Our ref: DOC20/419320

Senders ref: SSI 9973 MOD 1

Subject: Eastern Gas Pipeline – Modification 1 – Port Kembla Lateral Modification

Senior Team Leader, Planning (Illawarra)
Biodiversity & Conservation Division
Environment, Energy and Science

revision	no.	description	drawn	approved	date
	A	ORIGINAL ISSUE	GH	AG	15.05.20

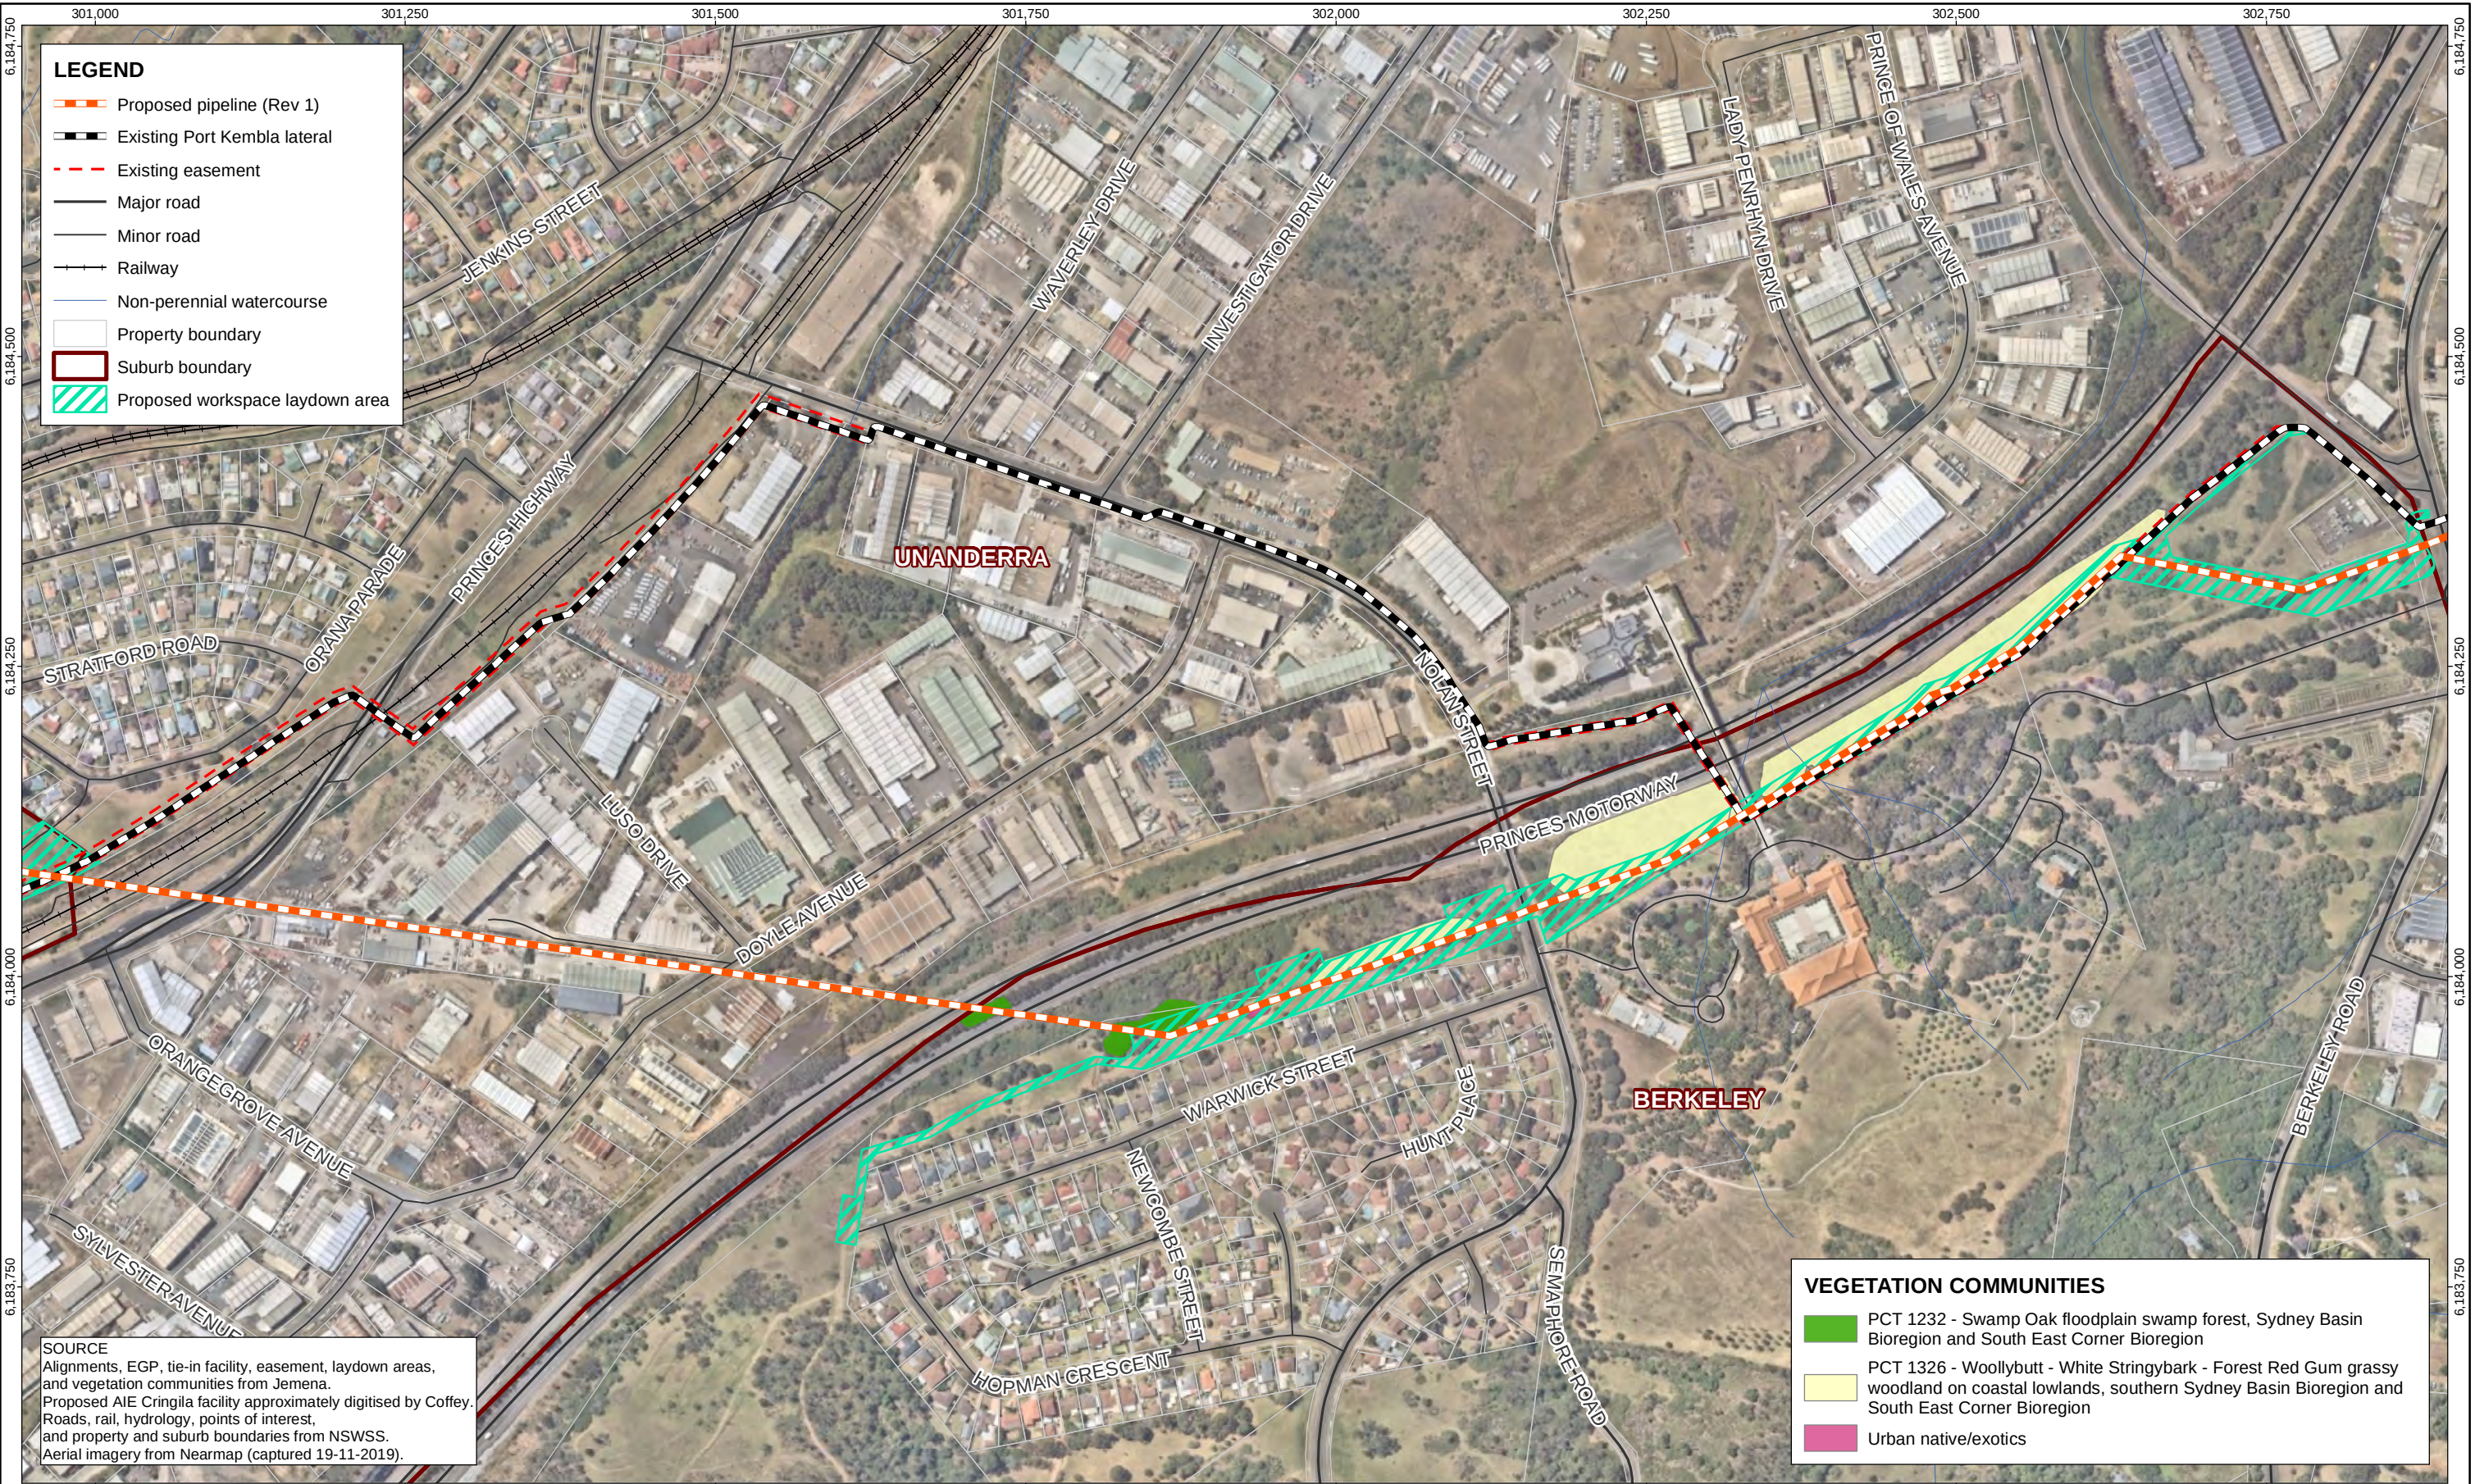
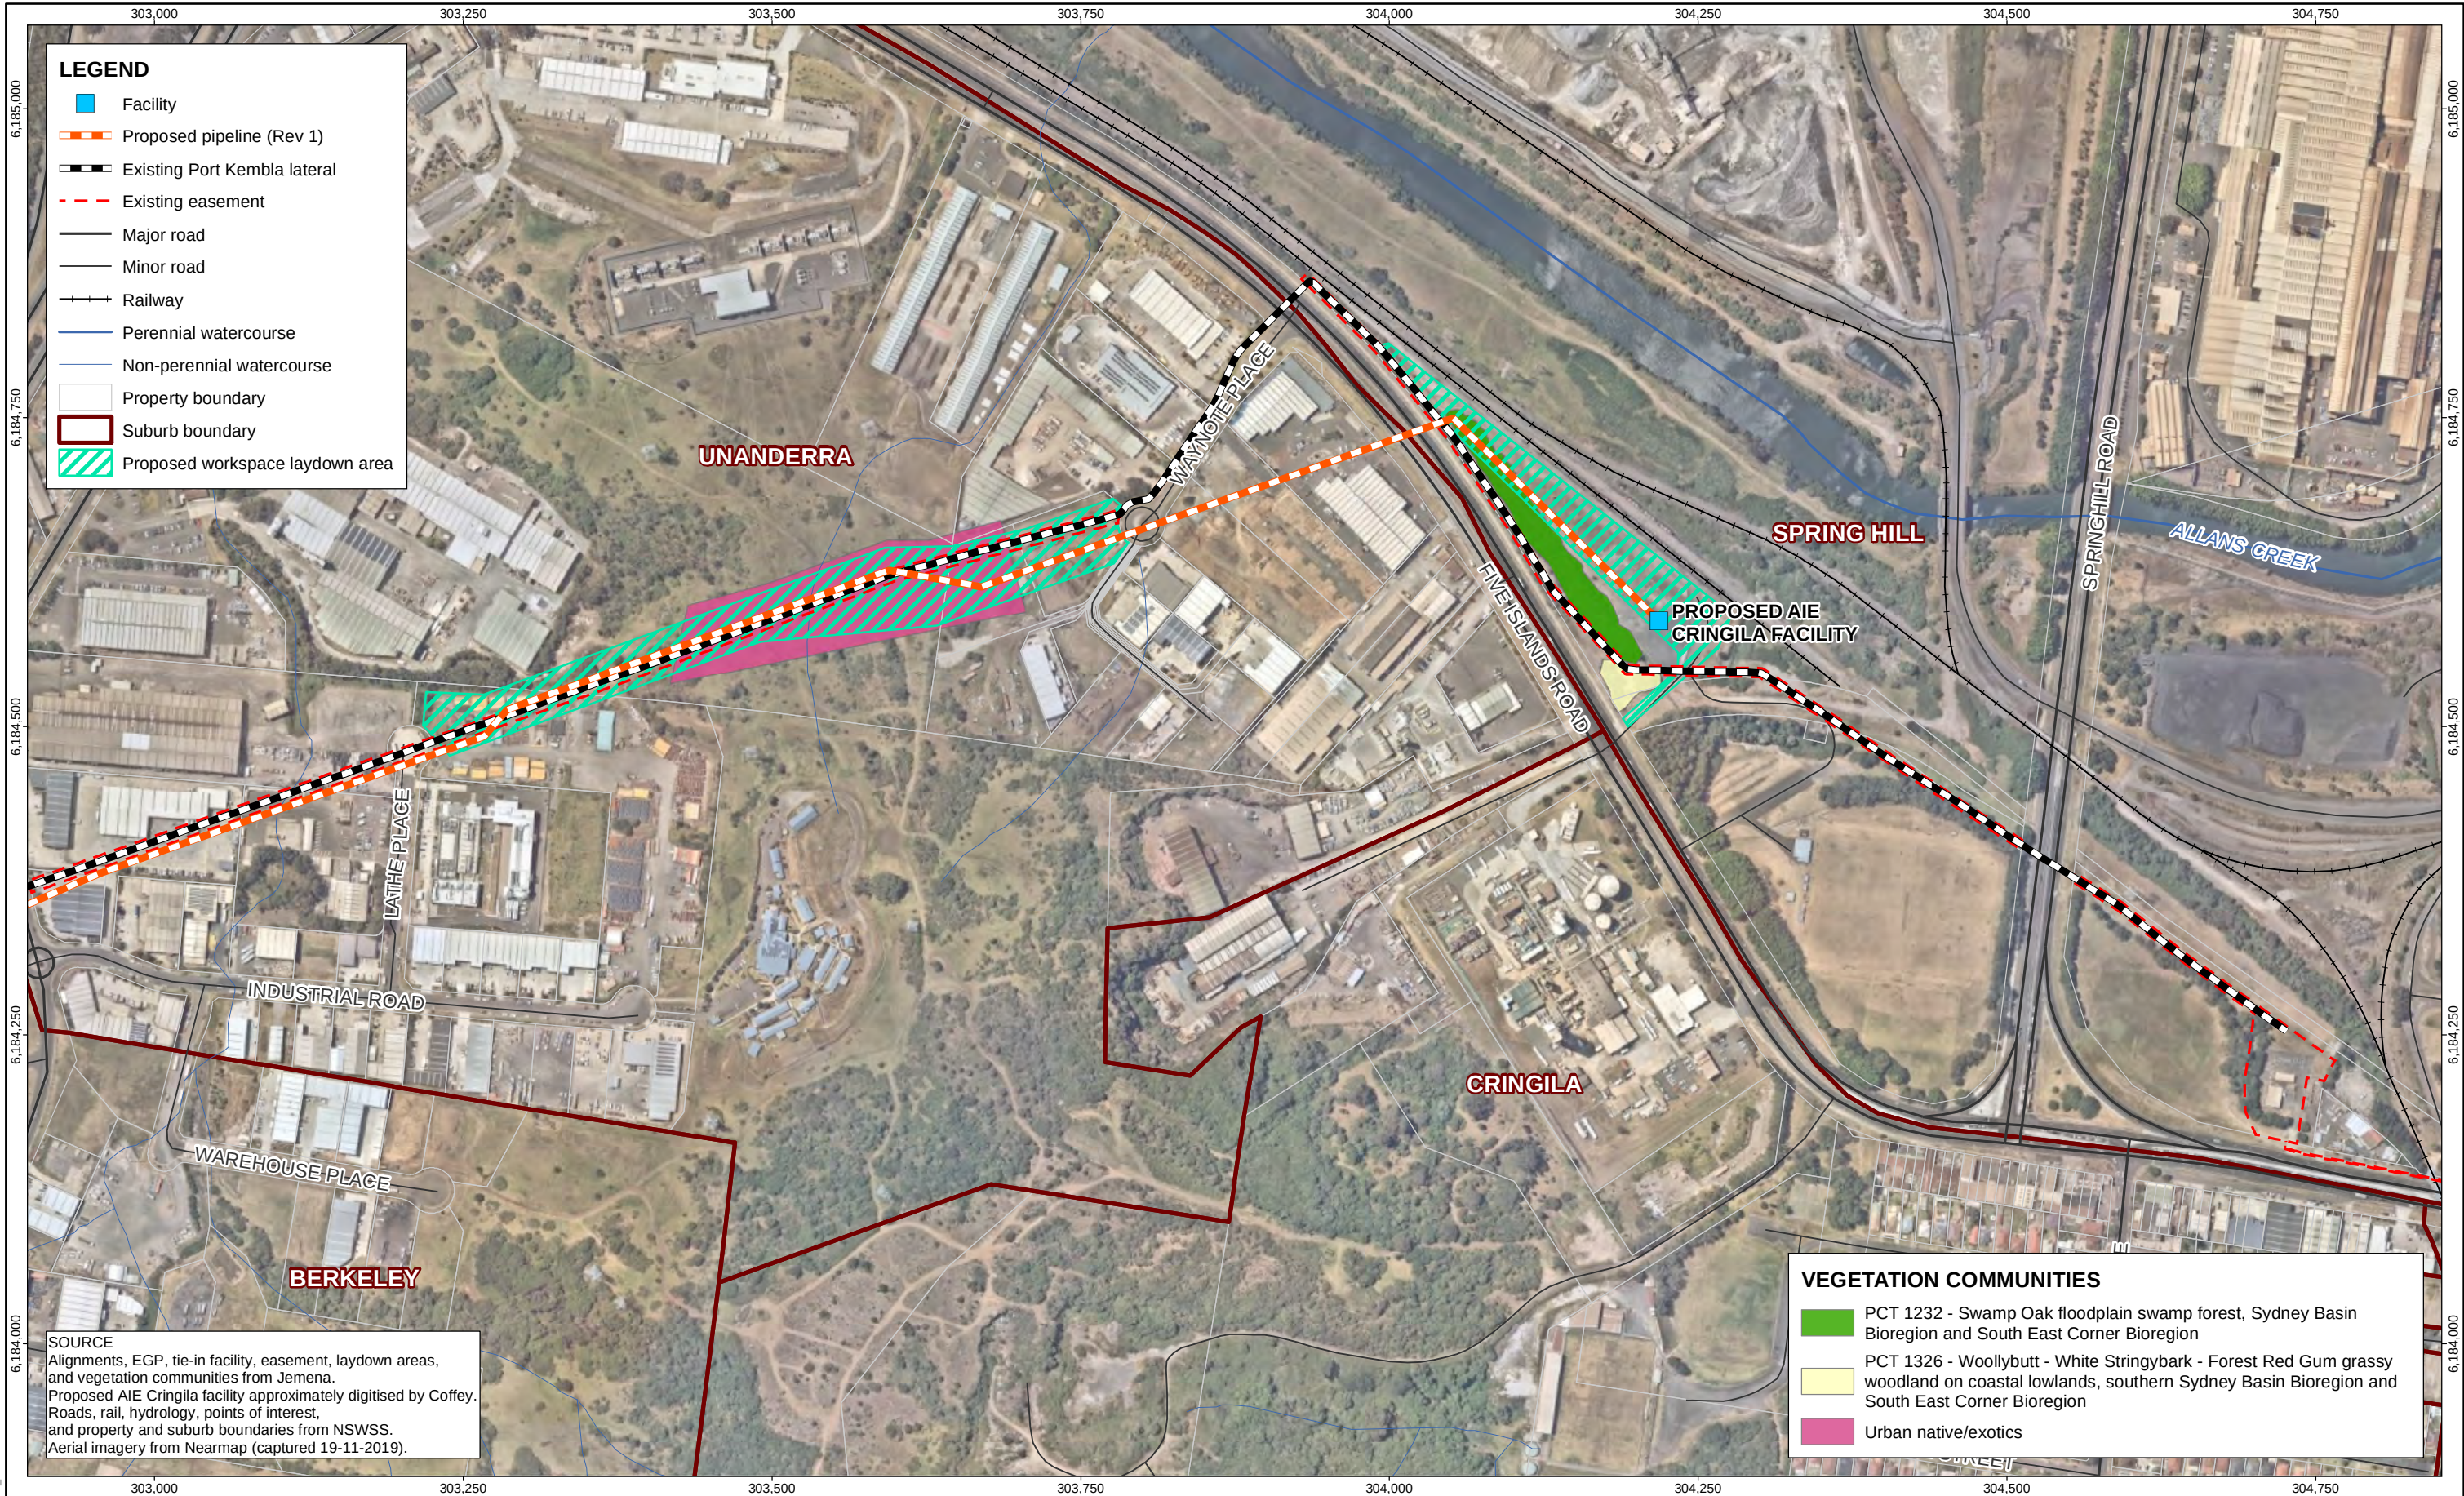
We have reviewed the Biodiversity Development Assessment Report (BDAR) and raise no objections to the findings. We note that the consultant has allocated some regrowth vegetation to the plant community type (PCT) 838, associated with the Illawarra Lowlands Grassy Woodland threatened ecological community (TEC), and a small drainage swale to PCT 781, associated with the Freshwater Wetlands on Coastal Floodplains TEC.

Impacts to both of the communities are minor and are proposed to be offset through the retirement of credits. Should the modification be approved, we recommend that appropriate conditions of consent be recommended requiring the retirement of the requisite credits. We remain available to assist with drafting of conditions of consent upon request.
